Recommendation Report for Lawful Development Certificate for a Proposed Use or Development

REF NO: LU/25/13/CLP

LOCATION: 53 Tideway
Littlehampton

PROPOSAL: Application for a certificate of lawfulness for a proposed single storey side extension

DRAWING TITLE
PROPOSED PART GROUND FLOOR
PLAN AND ELEVATIONS

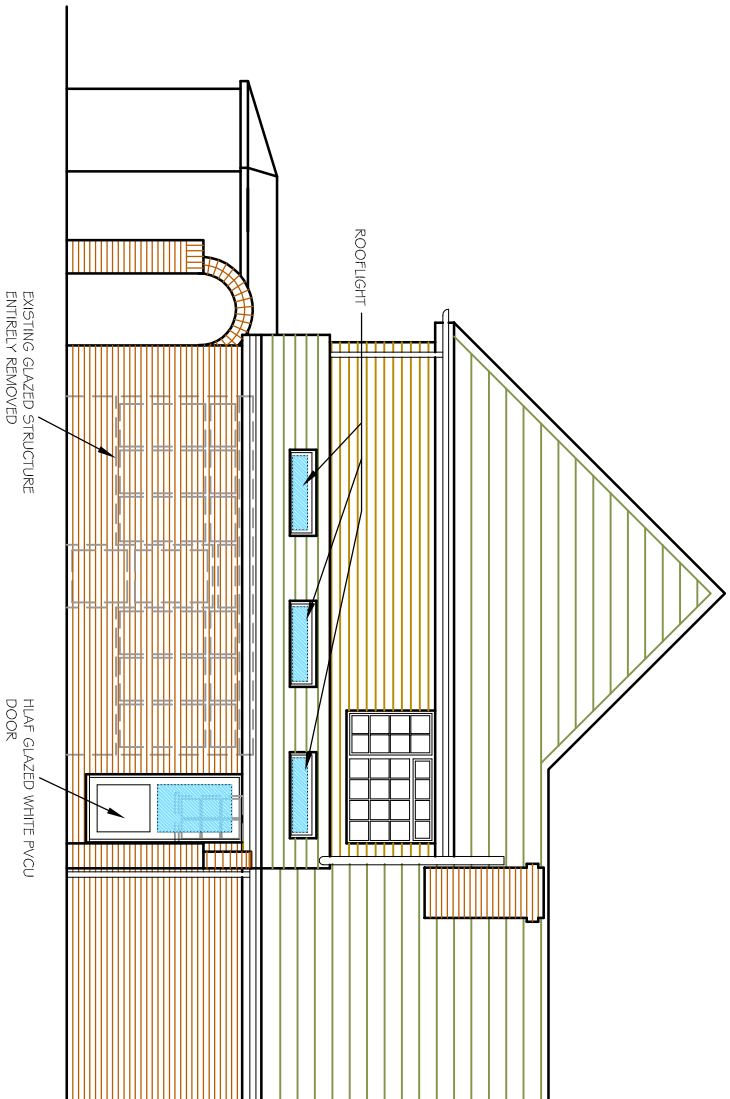
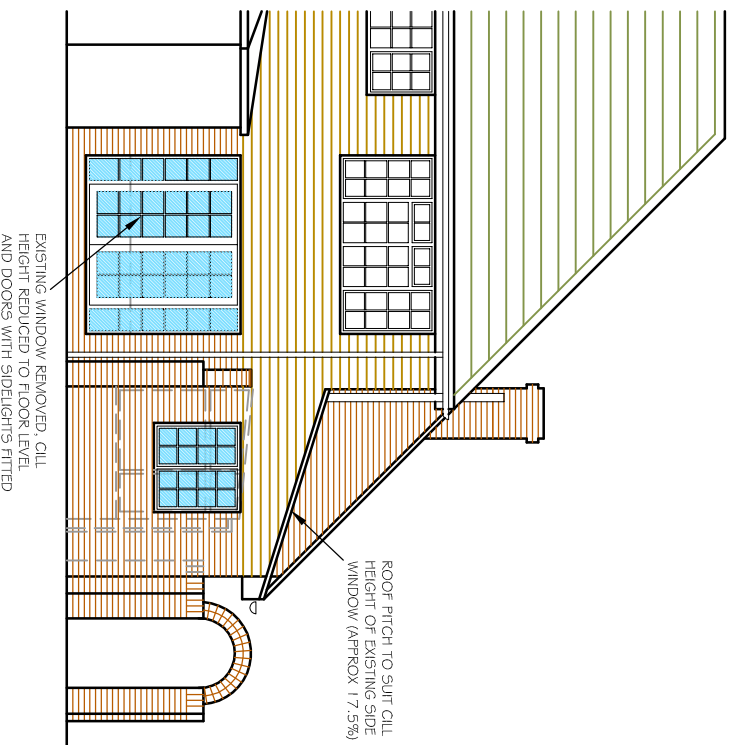
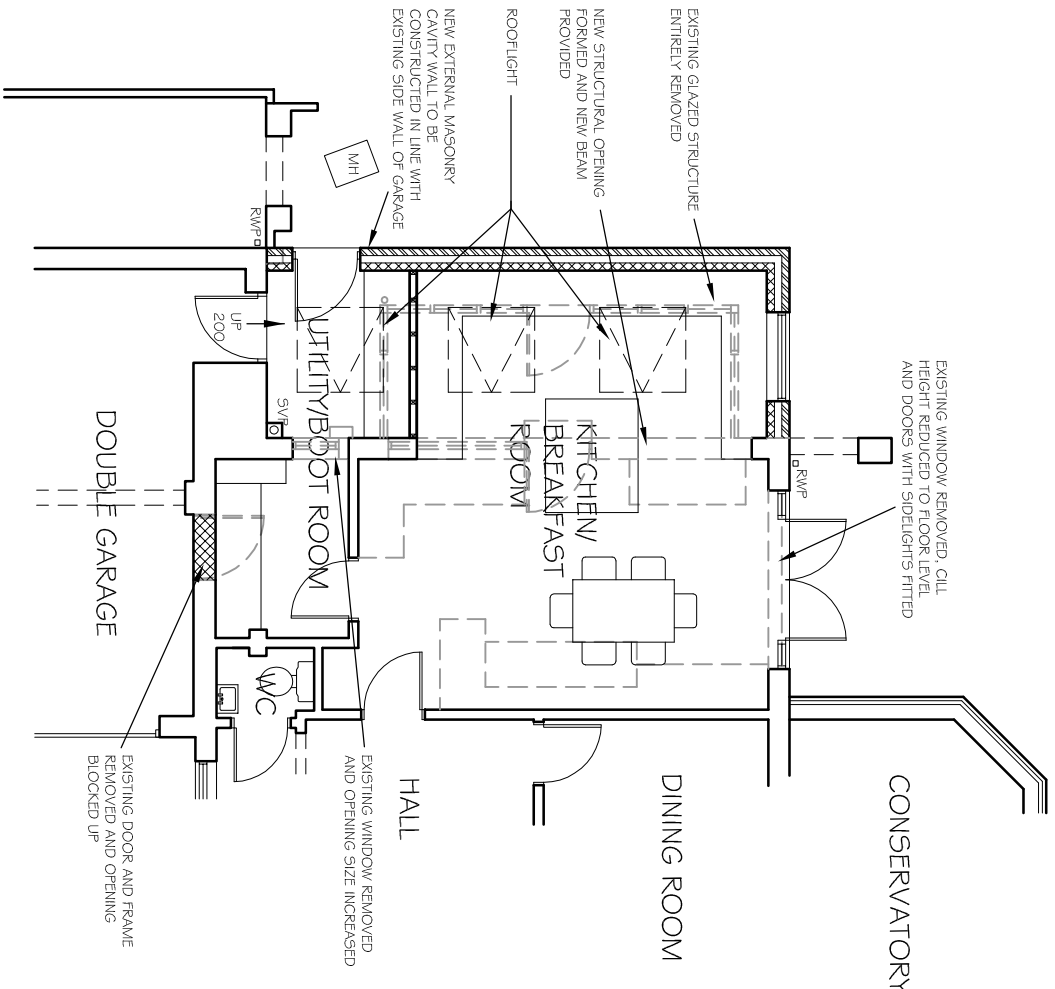
The proposed side extension would not result in the total ground covered by buildings within the curtilage of the dwellinghouse exceeding 50% of the total area of the curtilage. The proposal therefore complies with Class A.1(a).

The height of the proposed extension does not exceed the height of the highest part of the roof of the existing dwellinghouse. The proposal therefore complies with Class A.1(b).

The height of the eaves of the extension does not exceed the height of the eaves of the existing dwellinghouse. The proposal therefore complies with Class A.1(c).

The proposed extension does not front a highway and therefore complies with Class A.1(d).

The proposed extension is not to a rear elevation of the original dwelling and therefore complies with Class A.1(e) and (f).

The height of the eaves does not exceed 3m and therefore the proposal complies with A.1(g).

The proposed extension does not exceed 4m in height, is single storey and is less than half the width of the original dwellinghouse and therefore complies with Class A.1(h).

The proposal does not include construction of a veranda, balcony or raised platform, a microwave antenna, a chimney, flue or vent pipe or an alteration to any part of the dwellinghouse. The proposal therefore complies with A.1(i).

Class A.3 states that development is permitted by Class A.1 subject to conditions to ensure that external materials are of a similar appearance to those of the exterior of the existing dwellinghouse. The proposal complies with the above conditions as per notations on the submitted plans.
